12 Beaconsfield Close,
Middleton on Sea,
Bognor Regis,
PO22 7SH.

Ref : Planning Application M56 /17/HH - 8 Beaconsfield Close.

East Elevation

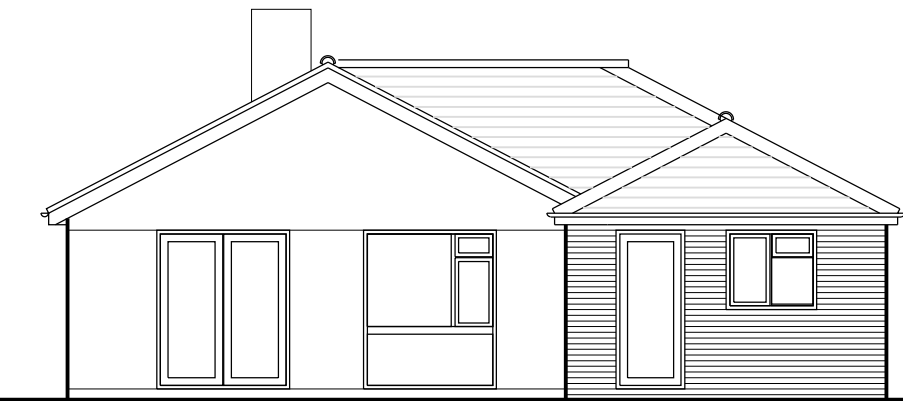
This is quite a large extension to No 8 and more on the lines of the new build of a one bedroomed bungalow coupled to the main bungalow at the roof, the eastern elevation of which overlooks my property at No 12. and will be quite intrusive.
